Item No. **Report of the Head of Planning, Transportation and Regeneration**

Address 13 HAYES END CLOSE HAYES

Development: Demolition of existing garage and erection of two storey side extension to dwellinghouse

LBH Ref Nos: **12748/APP/2022/167**

04 / 15

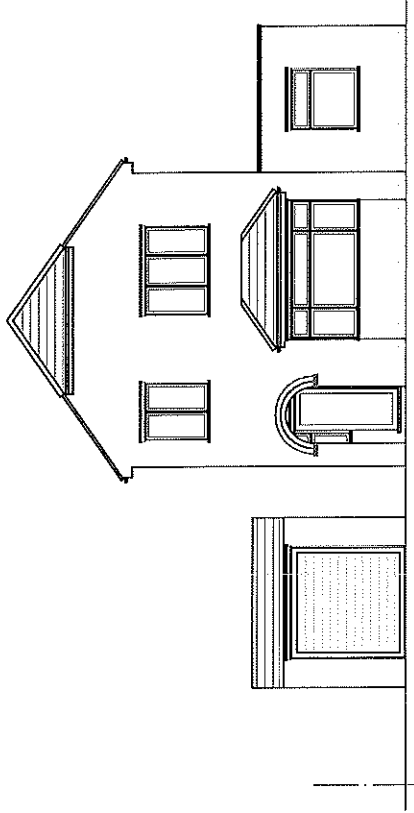
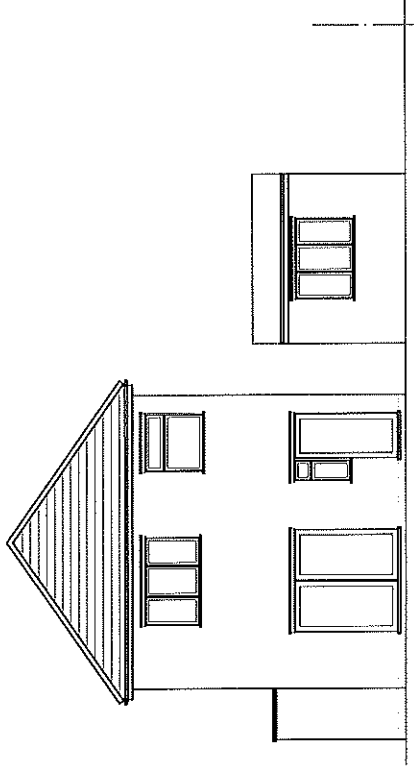
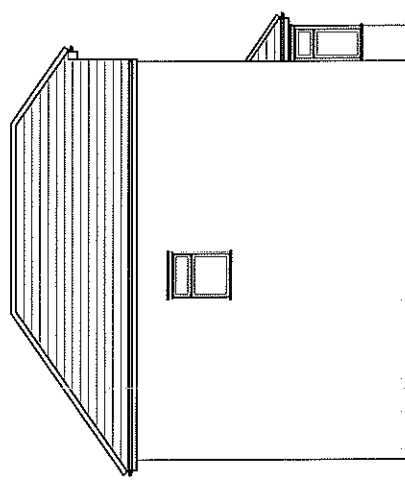
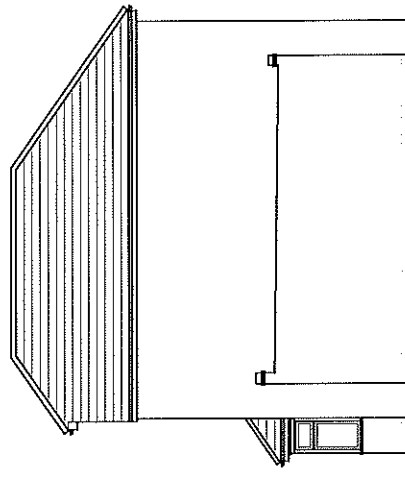
No. 13 Hayes End Close is sited on prominent corner at the junction of the Hayes End Close and Hayes End Drive. The proposed two storey side extension would replace an existing detached garage and would have a width of 4.4 metres, far greater than half the width of the original dwelling, in direct conflict with Policy DMHD 1. The associated roof alteration of the proposed two storey side extension would add bulk and height to the existing dwelling and dilute any degree of subordination, again in direct conflict with Policy DMHD 1. It is therefore considered that given the width of the proposed two storey extension and the additional bulk of the associated roof alteration that the proposed extension would not be a disproportionate addition to the host dwelling contrary to Policy DMHB 1 of the Hillingdon Local Plan: Part 2 - Development Management Policies (January 2020).

Furthermore, the site represents a very prominent corner plot. The proposed two storey side extension would therefore be highly visible from the front, side, and rear. Given that the side extension would protrude well beyond the established front building line of Hayes End Drive, the extension would close an important visual gap in the area which adds to the distinctive character to the locality. As a result, the proposed extension would be harmful to the streetscene and locality, not just the original building. It is therefore considered that the siting of the proposed extension combined with its height, bulk and mass would fail to maintain the character of the surrounding area and be out keeping with the established streetscene contrary to Policies DMHB 1 and 11 of the Hillingdon Local Plan: Part 2 - Development Management Policies (January 2020).

The proposed two storey side extension by reason of its siting, scale, bulk, height, design and excessive width would fail to read as a subordinate addition to the house and respect its architectural integrity. Given the prominent corner position of the site, the side extension would also result in the closing of an important gap characteristic to the area, fail to respect the established return building line and overall result in harm the established character and appearance of the area. The proposal would therefore represent an overdevelopment of the site to the detriment of the visual amenities of the street scene and the surrounding area, all contrary to Policies DMHB 11 and DMHD 1 of the Hillingdon Local Plan: Part Two - Development Management Policies (January 2020).

02 / 15

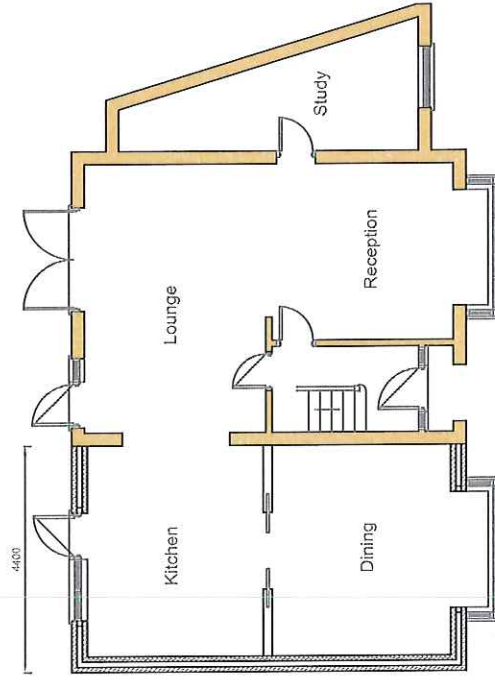
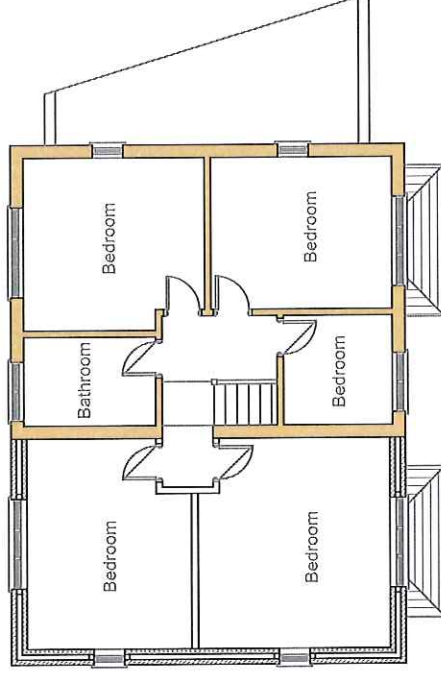
Given the detached nature of the dwelling and its siting on a corner plot, the proposed would be set away from neighbouring dwellings and screened by the existing built form. The proposed first floor rear windows would not result in any additional overlooking of neighbouring amenities.
